From: Martyn White
Sent: 10 July 2019 10:44
To: Maria Tomalova <Maria.Tomalova@arun.gov.uk>
Subject: BR/120/19/PL & BR/121/19/L

BR/120/19/PL & BR/121/19/L

"Reinstatement of missing pieces of ornamental metalwork; redecoration of entire structure; removal of yellow brick plinth and step, and reinstatement with red brick; relocation of entrance gate from south elevation to west elevation; infilling of open east and west sides with new railing to match existing; removal of existing lighting and provision of new; fitting of horizontal ceiling; removal of concrete floor finish; laying of new non-slip tiles in geometric pattern; fitting of Perspex sheeting at high level to prevent rainwater penetration & fitting of Perspex sheeting behind balustrading to form windbreaks

The bandstand is a Grade II Listed Building. It is located on the promenade over-looking the beach.

PROPOSED REFLECTED CEILING PLAN

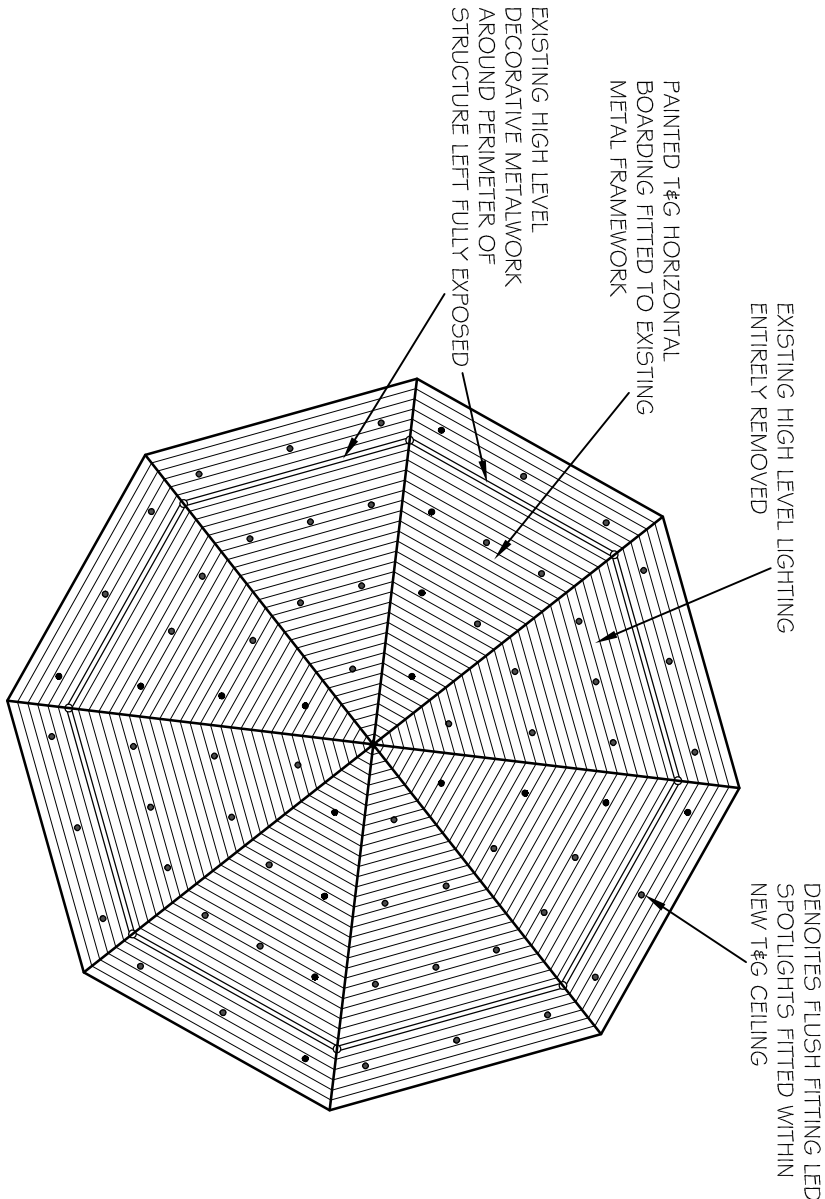
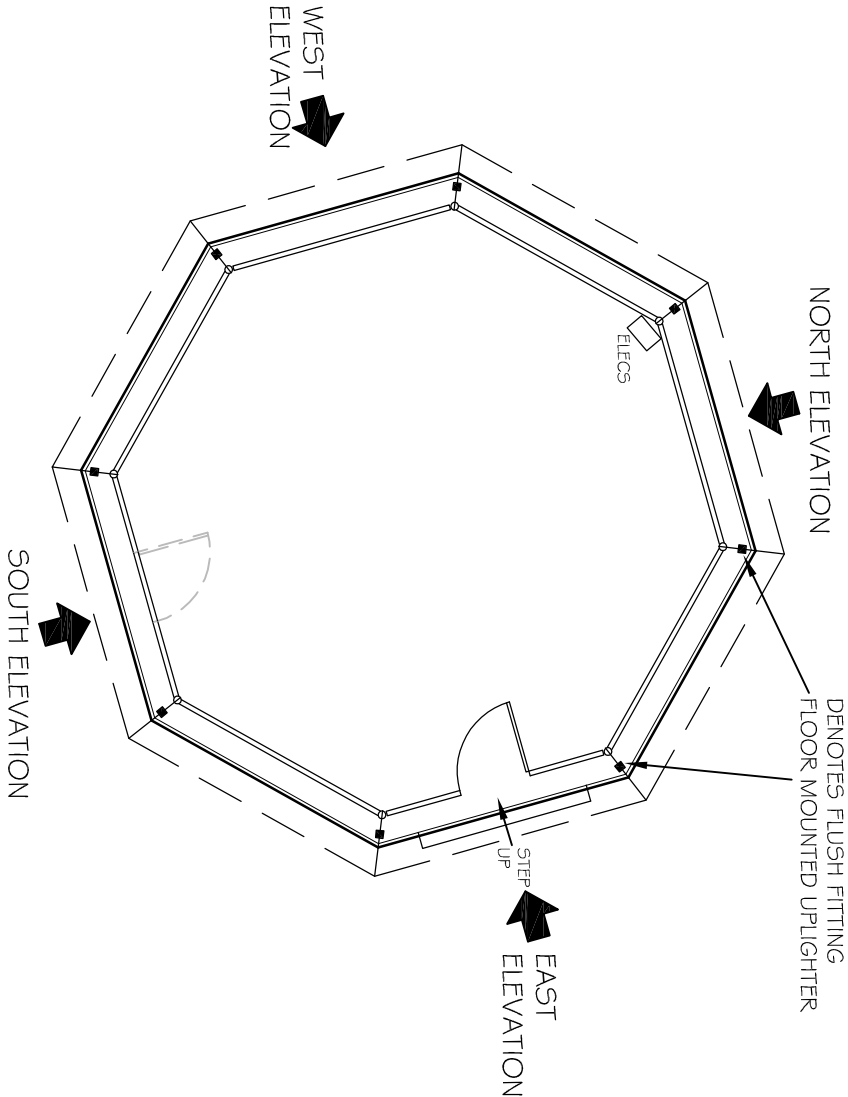
Also how will the horizontal timber boarding to be fitted below the roof structure to form a ceiling be treated?

DWG NO 824/04

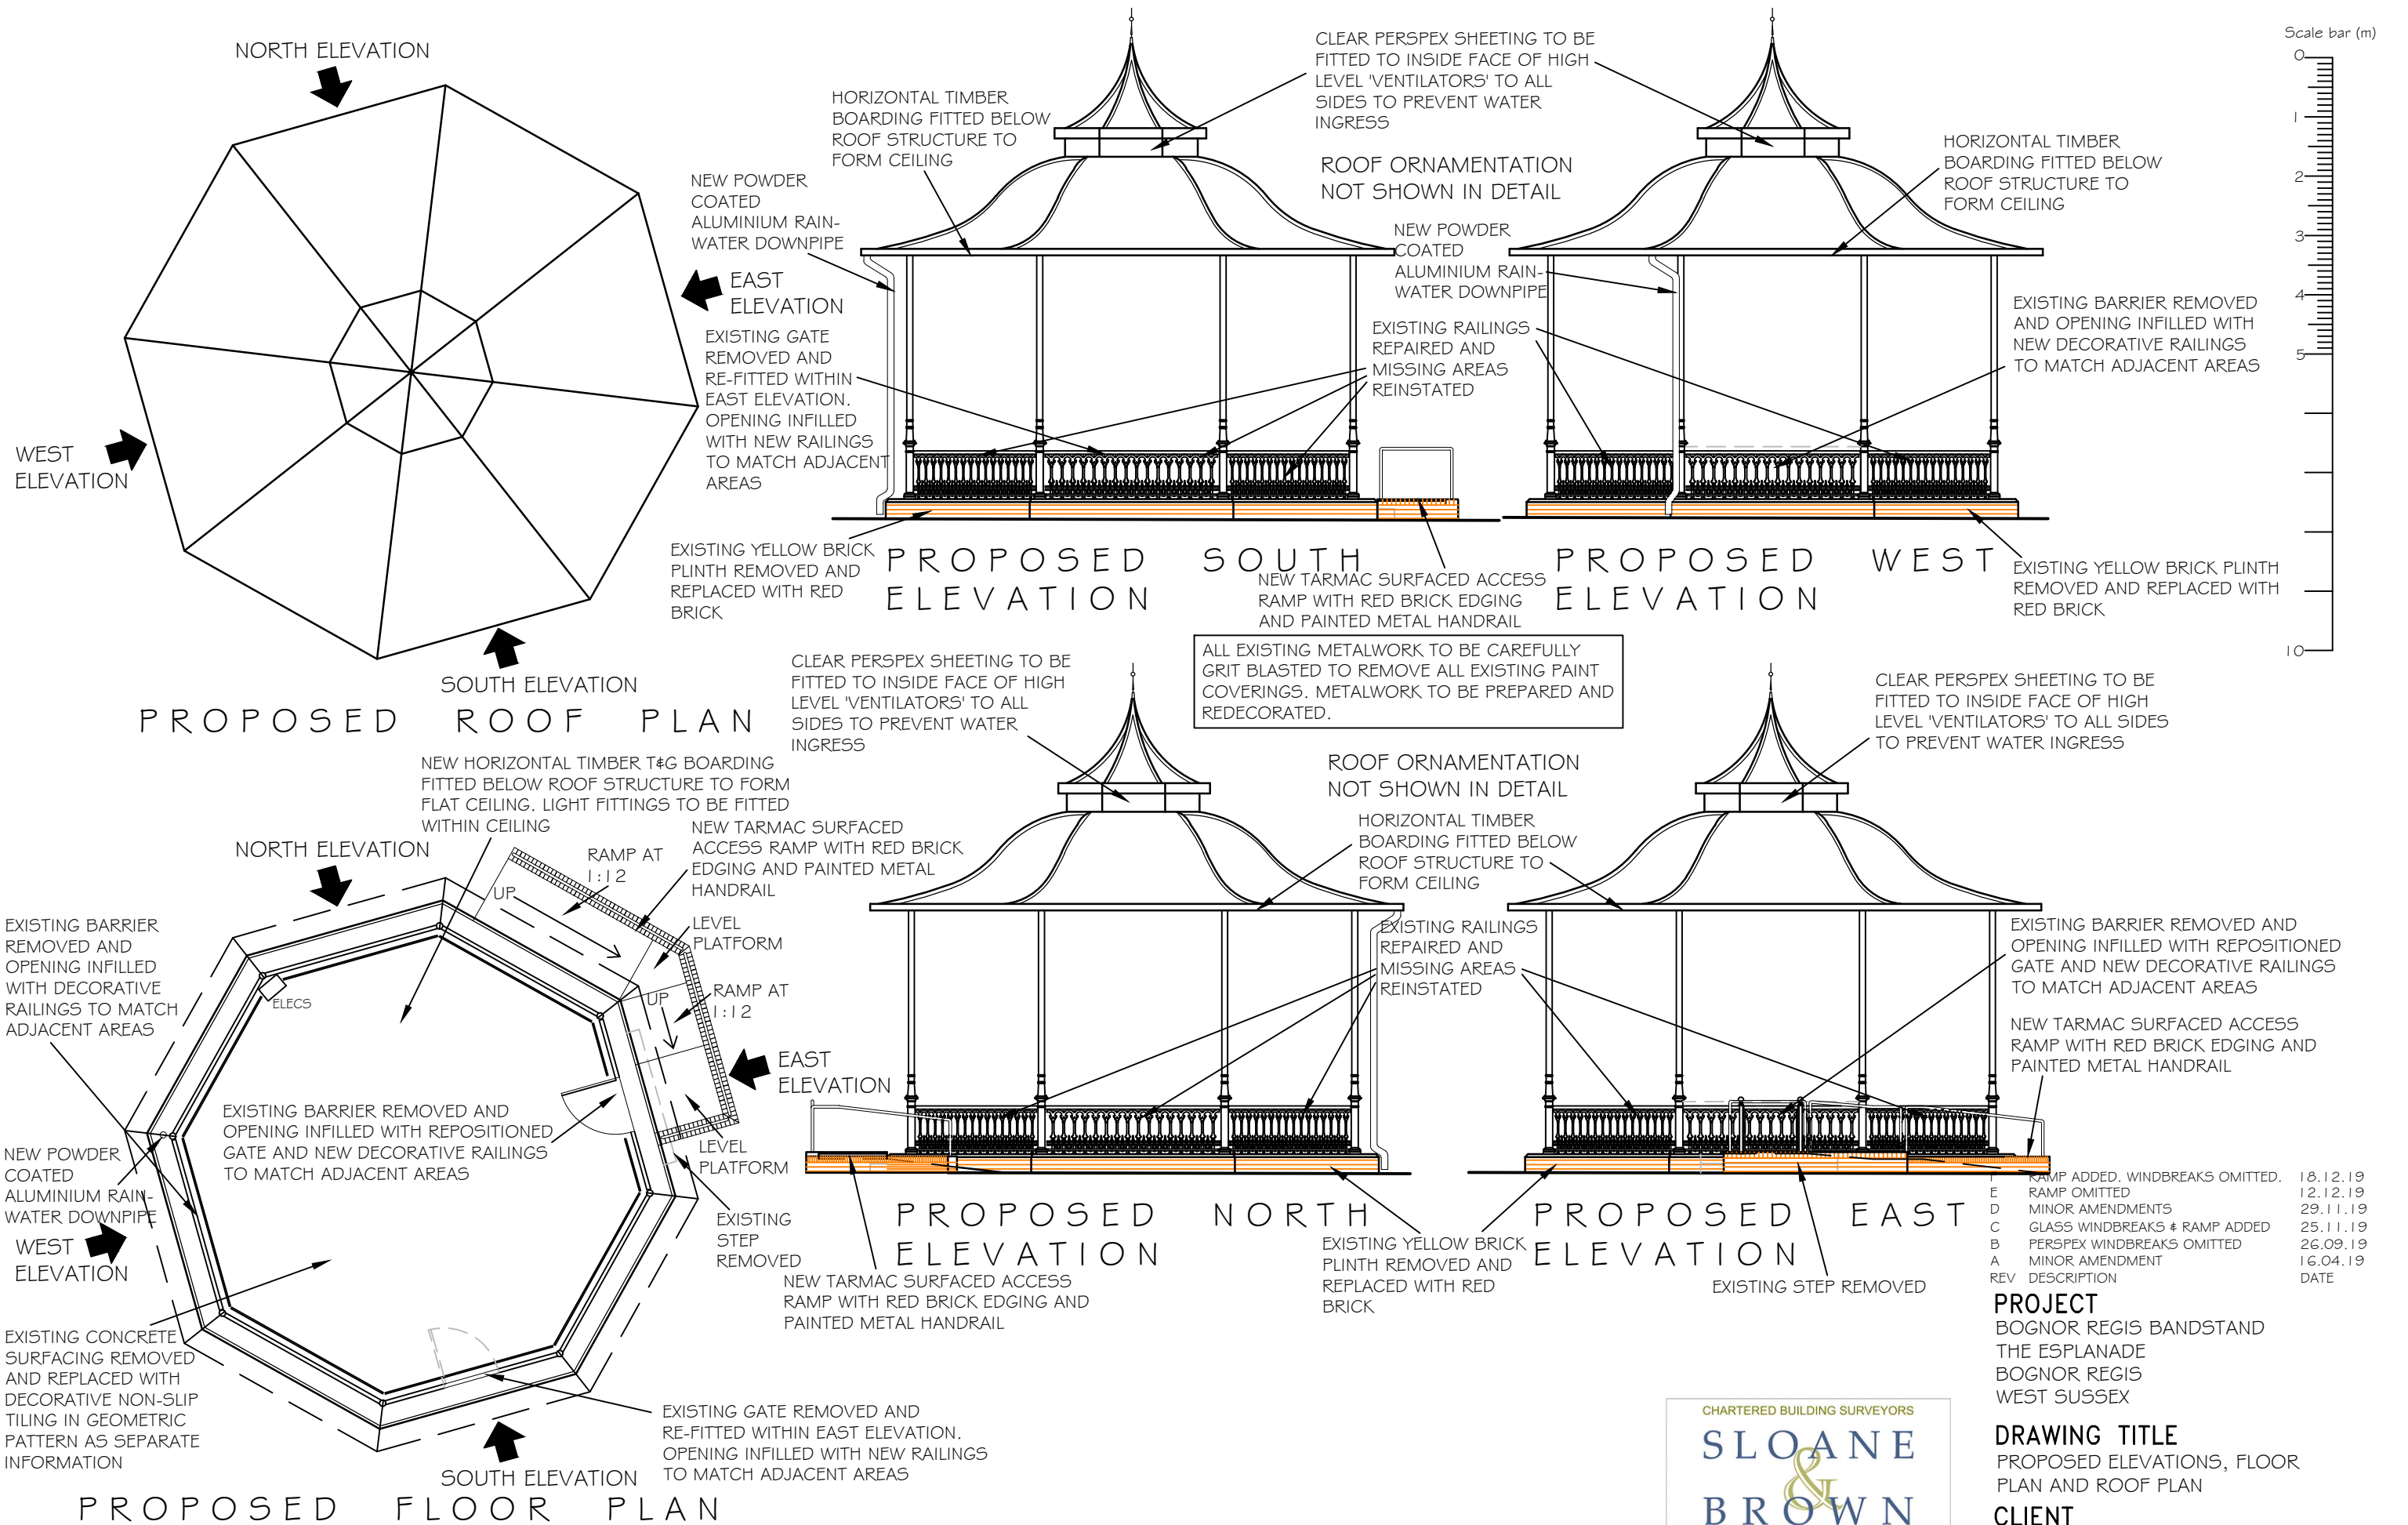
However, there are some issues which require clarification. It is not clear from reviewing the information why the location of the gate is to change.

Further, scant information has been provided regarding the proposed Perspex sheeting; how will it be fixed to the structure? Will it form a permanent element of the structure, or will it be used on a temporary basis (and removed when not required)? Further, what size will the panels be? What would the quality of the materials used be? At present, such an issue is considered to be problematic.
